**CITY OF PORTLAND, MAINE
Portland Exposition Building Drainage Improvements
Bid #5709**

Current Date: March 13, 2009

NOTE: The following is a response to questions recently received on this bid. PLEASE NOTE WE WILL NOT BE ABLE TO RESPOND TO ANY FURTHER QUESTIONS RELATED TO THIS BID.

**C-01**

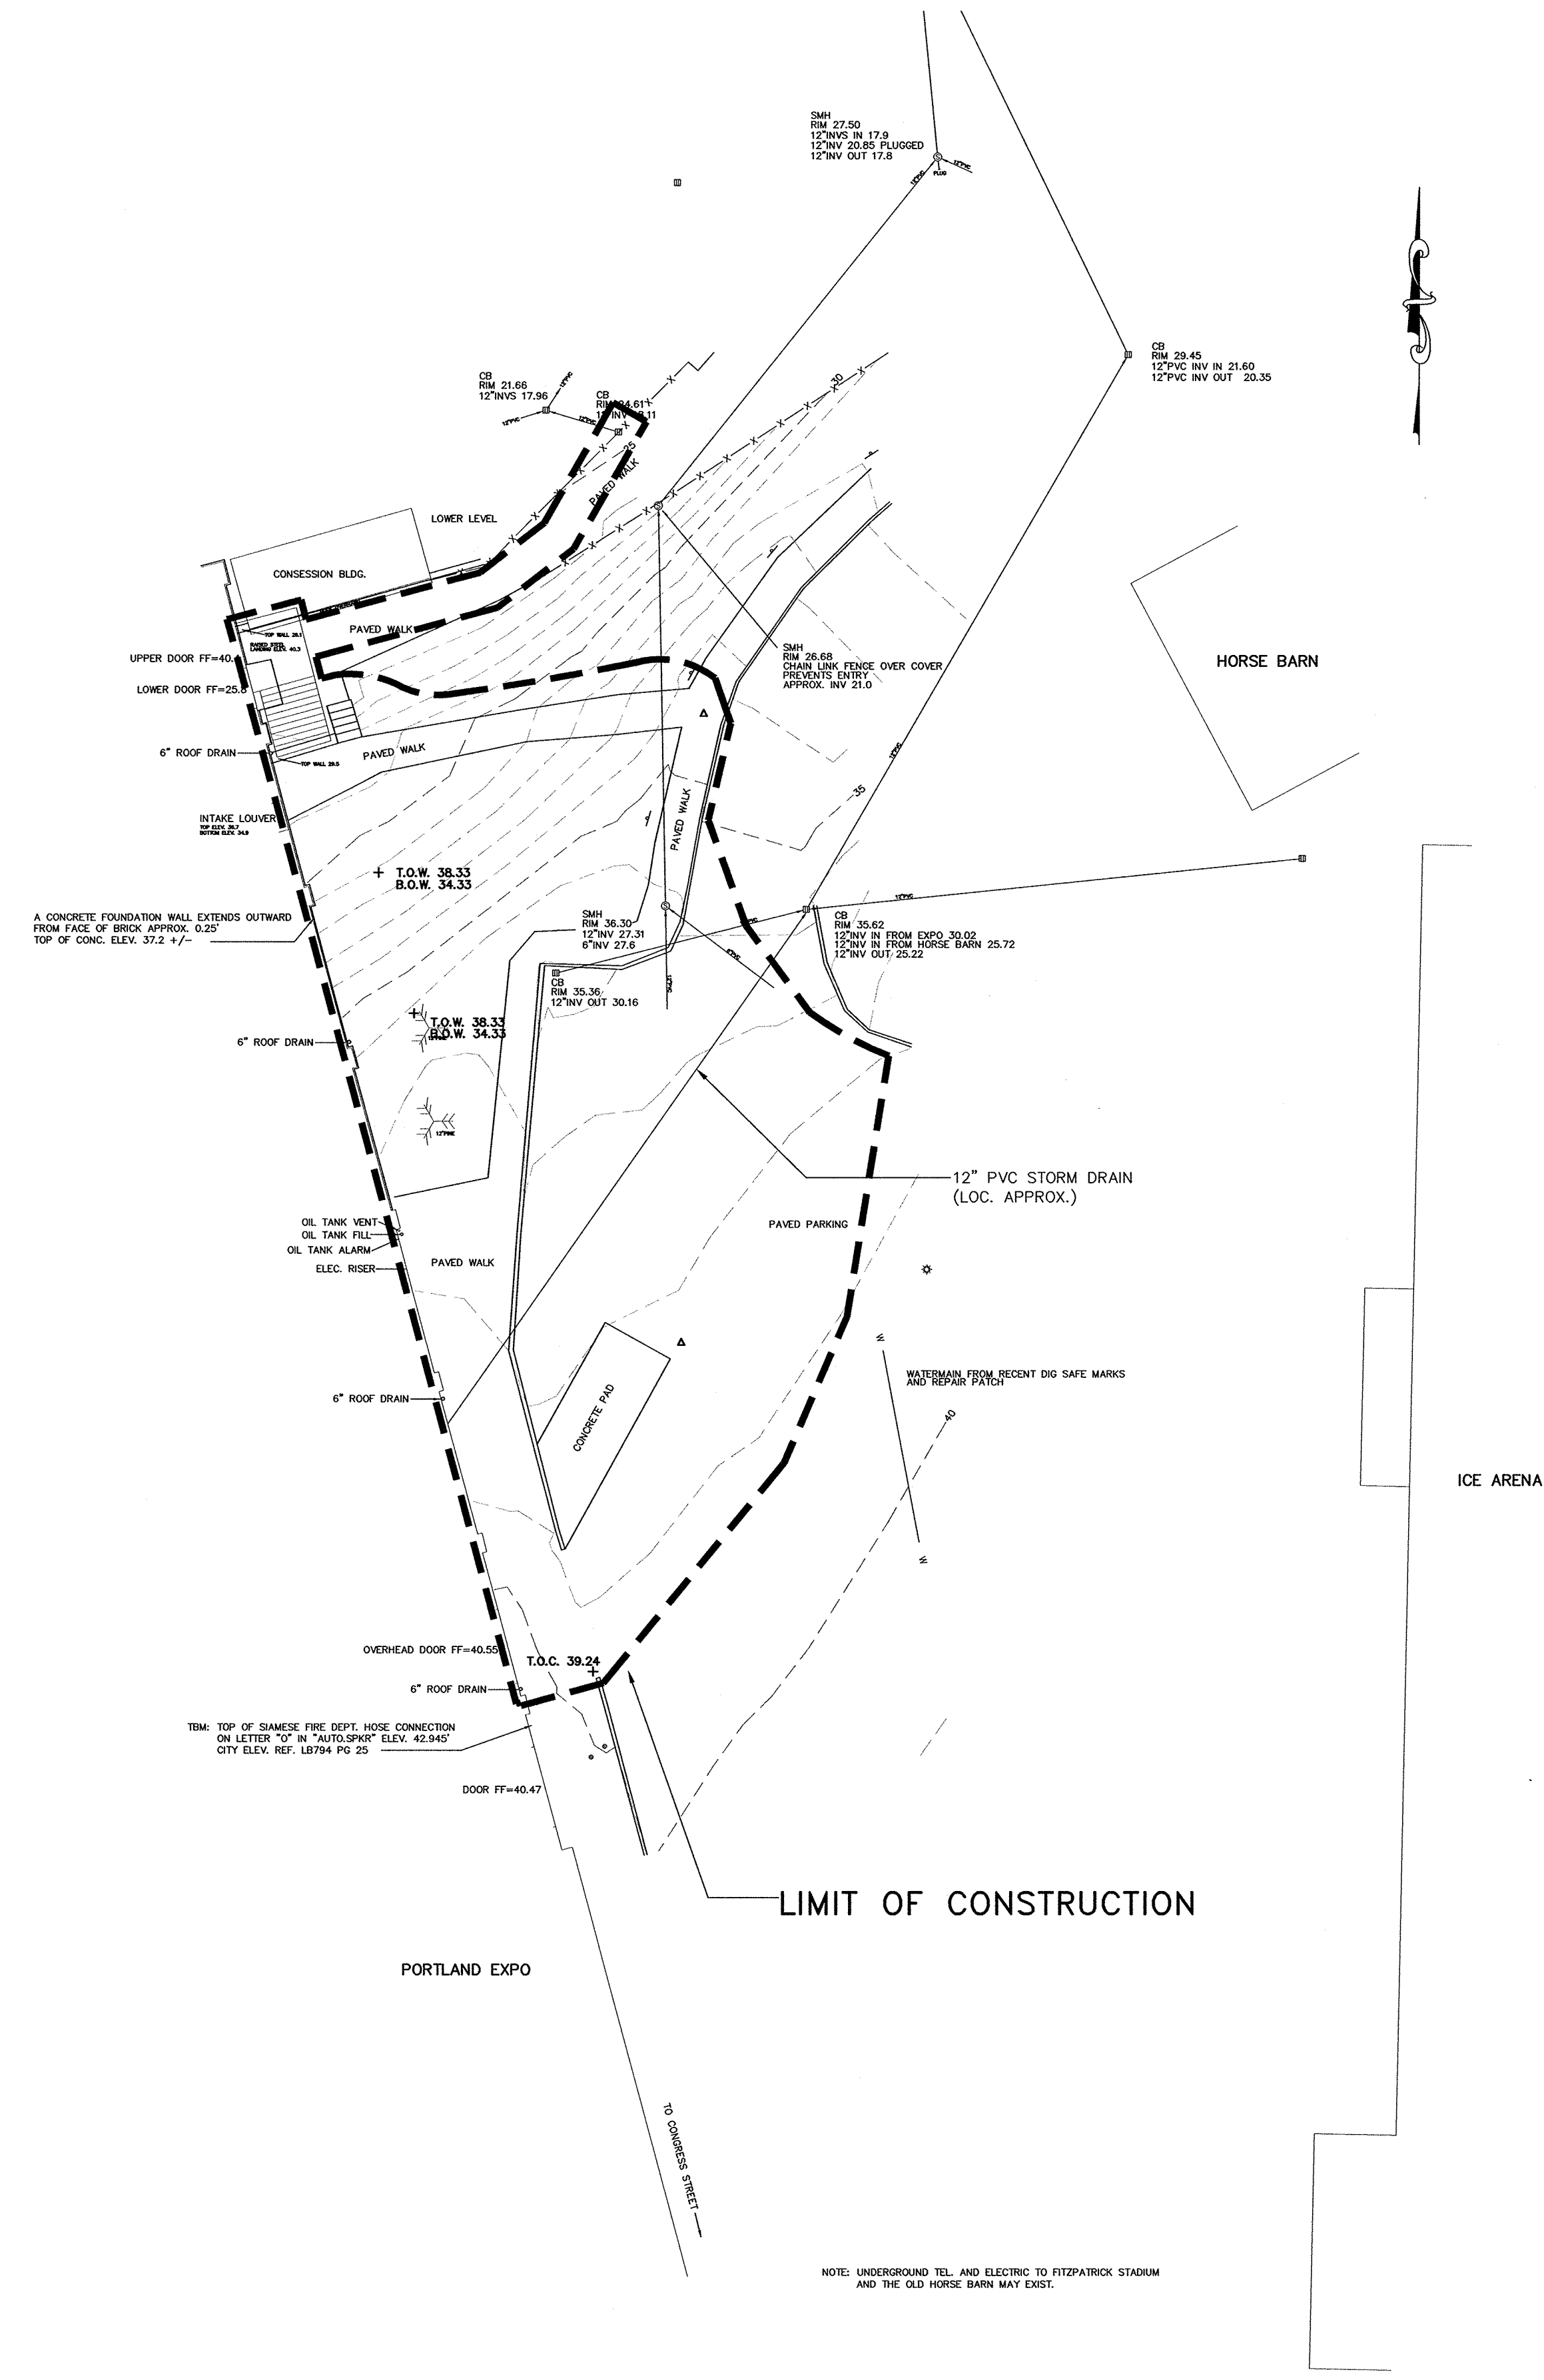
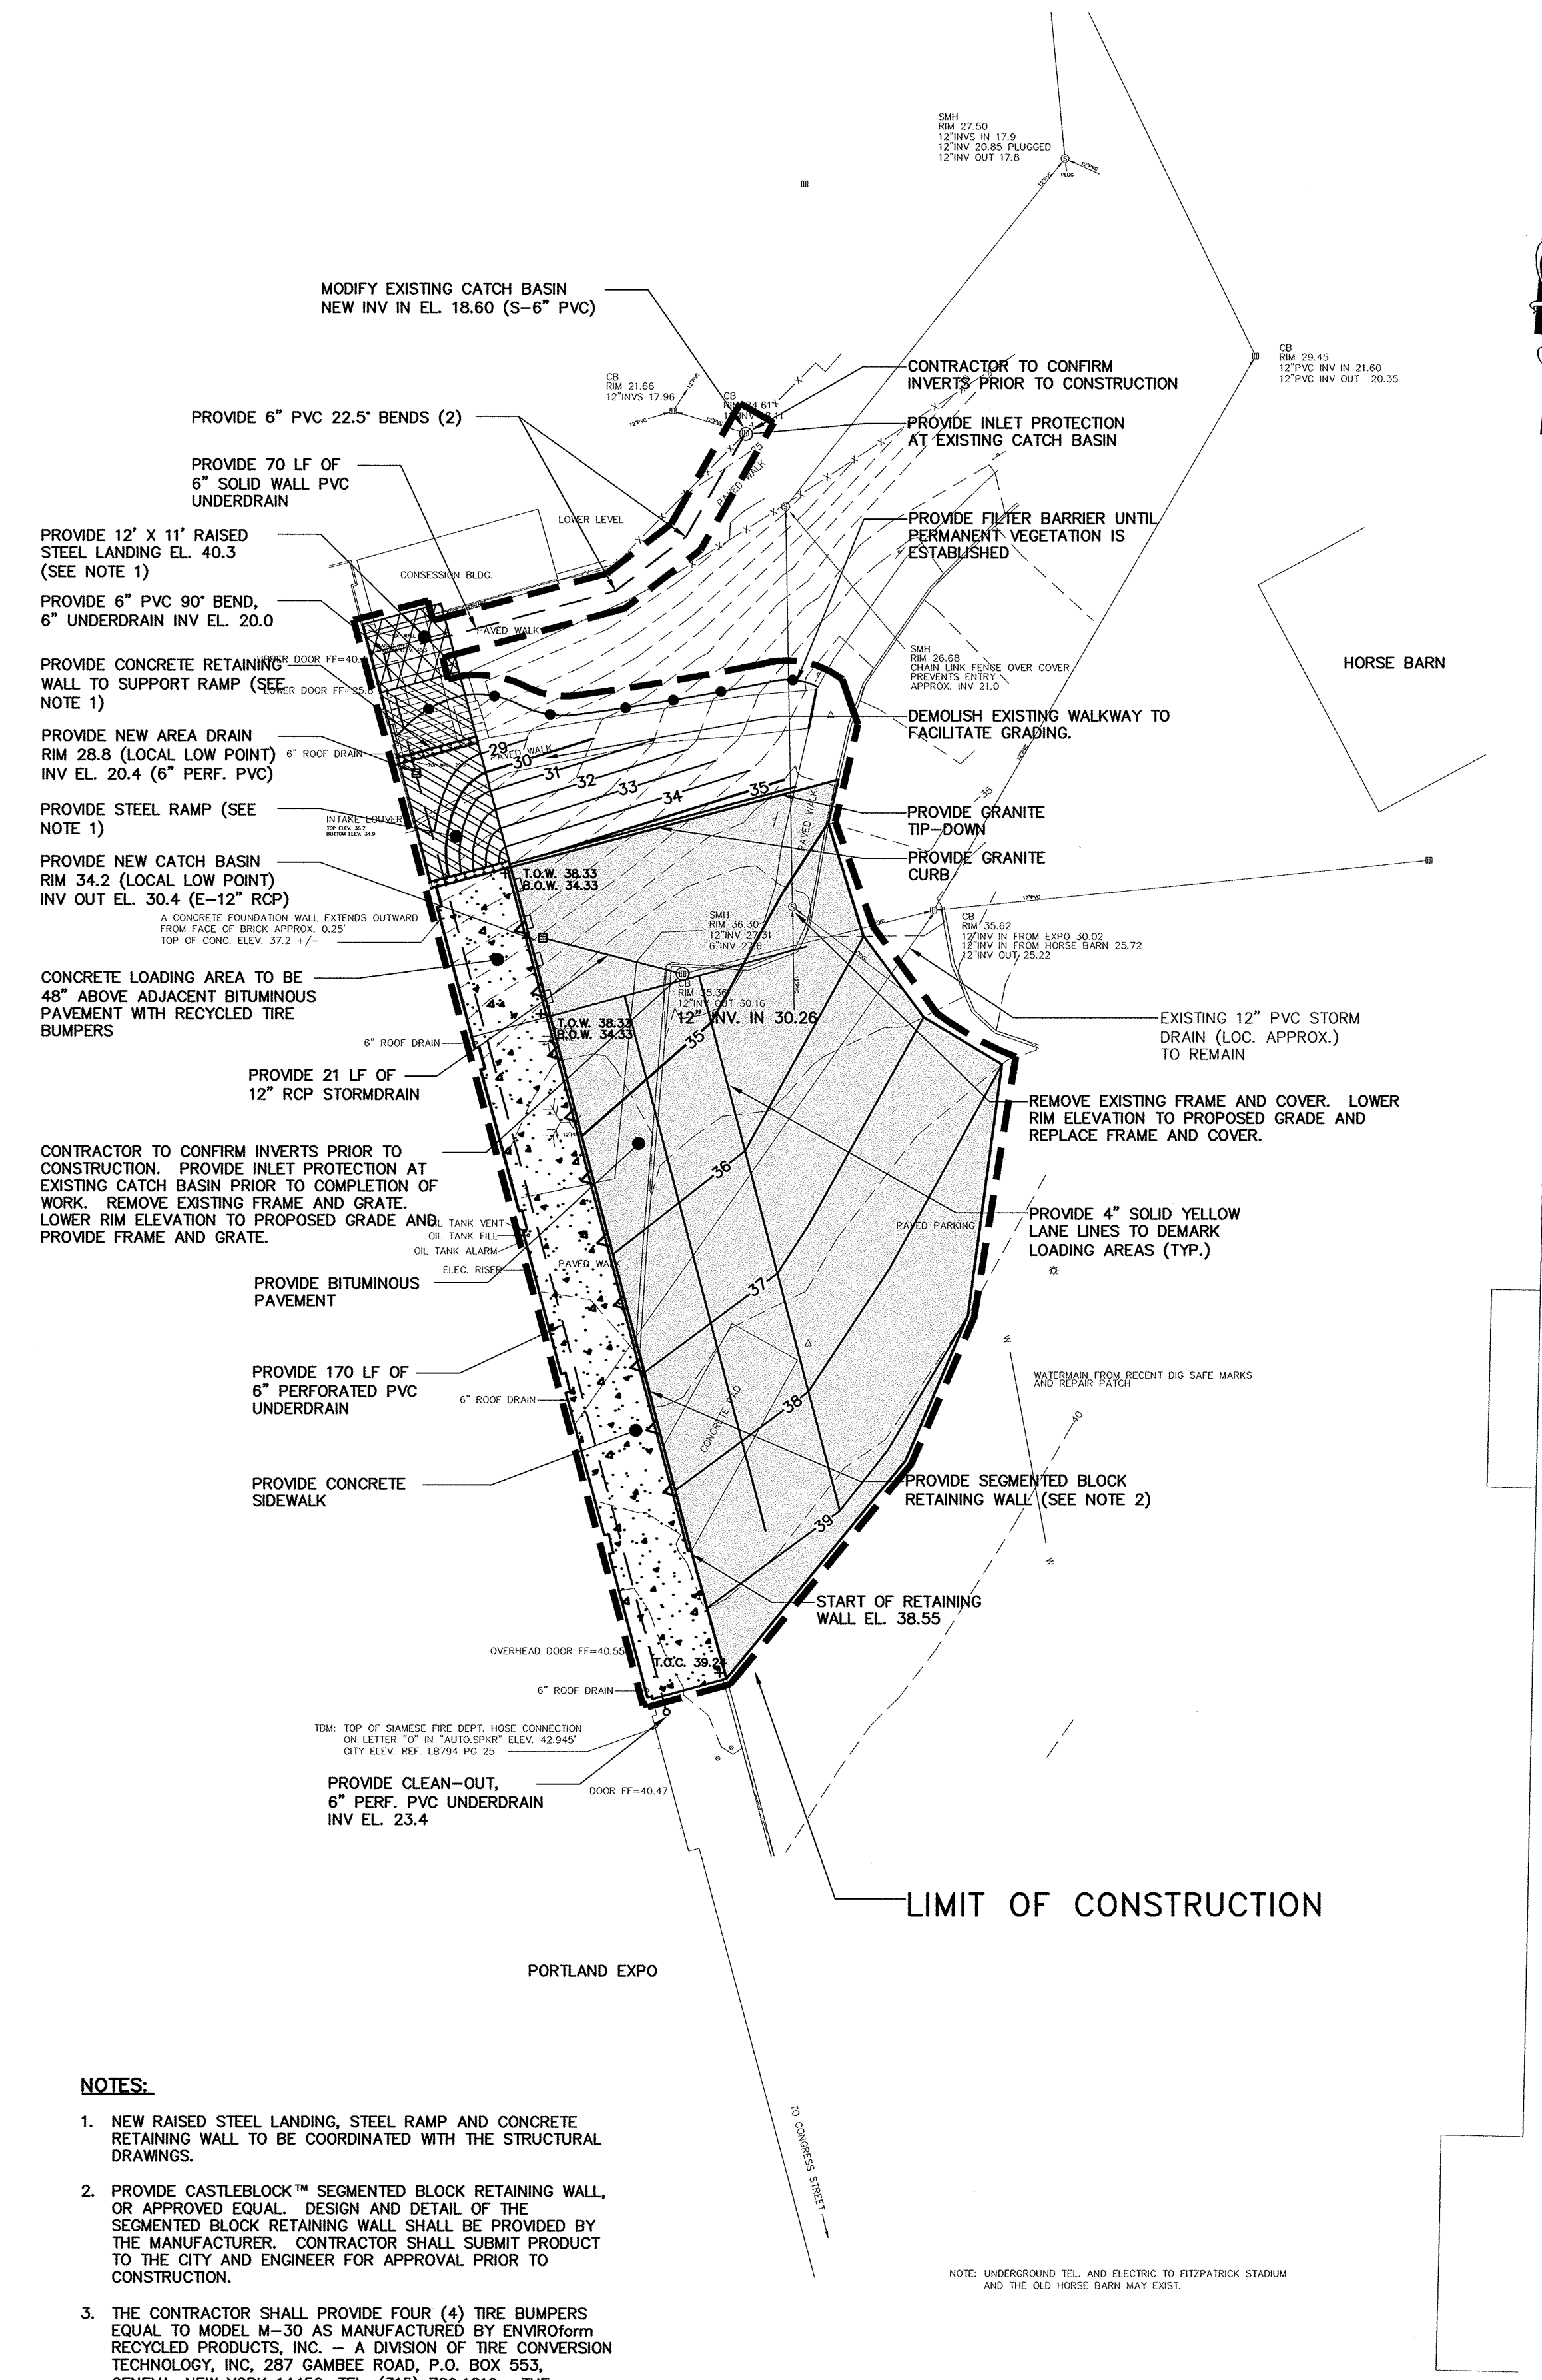
1. *Per Pg. 4 of - need to know how far - lineal footage of piping will be required to relocate the oil tank, oil tank vent, and oil tank alarm? What will be considered an acceptable means of construction for wall patching?*

3. *What is the acceptable manner to the city required for patching the (4) - 6" roof drain holes in the existing Exposition building?*

There is no requirement to relocate the oil tank. Existing fill, vent and alarm should be raised (less than 3') to proposed grade to accommodate the installation of the concrete sidewalk; all work must be completed in accordance with applicable codes and regulations (per Addendum 1). See Response to Question 3 within this Addendum for wall patching requirements.

CONTRACTOR shall cut off/remove the roof drain wall extensions flush with the exterior wall. The drain connects in-line to an active storm sewer. CONTRACTOR shall

take measures necessary to ensure that grout does not flow into the storm sewer by providing backer material behind proposed grout plug. The remaining thru-wall pipe shall be packed solid with cementitious, non-metallic, non-shrink grout meeting ASTM C 1107, grade c. Grout shall be Five Star Grout as made by U.S. Grout Company, Crystex or Premier as made by L&M Construction Chemicals, Inc., Sure-Grip High Performance Grout, as made by Dayton Superior, or approved equal. The existing joint between the pipe and existing wall shall be sealed with a backer rod, as required, and polyurethane sealant meeting ASTM C 920, Type M, Grade NS, Class 25, USE M,O.
